Our Ref: 2190140
Council Ref: SSD 8517 & SSD 8449 MOD 1

**RESPONSE TO SUBMISSIONS
SSD 8517 & SSD 8449 – MOD 1
LOCOMOTIVE WORKSHOP, SOUTH EVELIEIGH**

Figure 1 Proposed Locomotive Workshops Stormwater Treatment Train

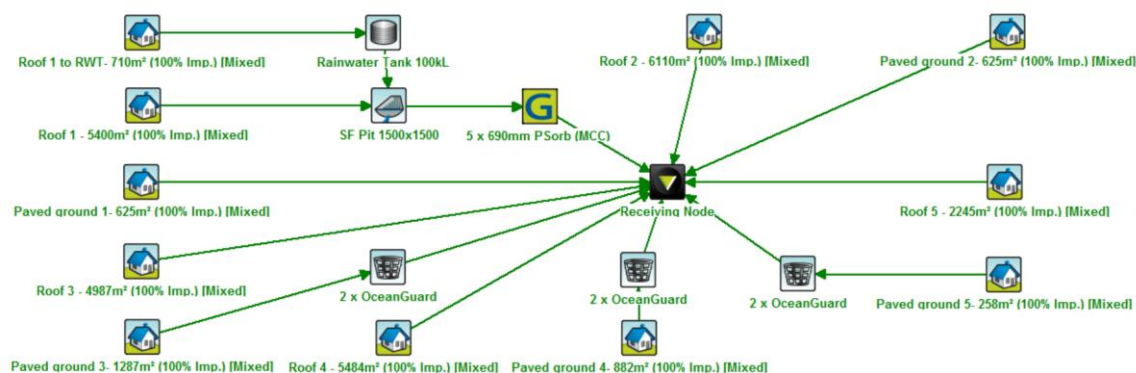
The proponent is seeking to significantly lower the standards to 25% (90%), 30% (85%), 10% (65%) and 10% (45%). The numbers in brackets are the DCP target standards. It is our understanding that the proponent's reasoning for the changes is that the existing building and storm water drainage system will remain unchanged and they have only considered a stormwater treatment system comprising filter baskets being installed within the existing gully pits to remove pollutants from the stormwater run off.

The Department are advised to request the proponent consider a stormwater treatment system incorporating new Gross Pollutant Traps and similar stormwater quality improvement devices that will enable the specified targets to be met.

- notwithstanding the view that the Locomotive Workshop should be exempt from meeting the standard Sydney Water targets, Mirvac and Harris Page & Associates have undertaken extensive modelling and conceptual design to gain an understanding of how to best achieve a satisfactory level of discharge quality improvement with the aim being to satisfy the pollution reduction targets set out in Conditions B29 and B25. However, during the modelling and conceptual design development it was clear that in order to achieve the required targets, a complex system of low-flow by-pass manifolds that connect to Stormwater Quality Improvement Devices (SQIDs) would be required. The impact of implementing the low flow by-pass manifolds and SQIDs would require additional penetrations through the northern and southern façades of the Locomotive Workshop and therefore present considerable risk to the heritage assets due to:

- the existing Locomotive Workshop building occupying approximately 91% of the overall site area; and
 - the required positioning and size of the SQIDs would require penetration of the heritage northern and southern facades, and potentially compromise the ground conditions due the substantial excavation in close proximity of the inground heritage structure and footings;

- whilst the pollutant reduction targets currently set out in Conditions B29 and B25 cannot be met, a reduction can still be achieved that provides a Neutral or Beneficial Effect (NorBE);
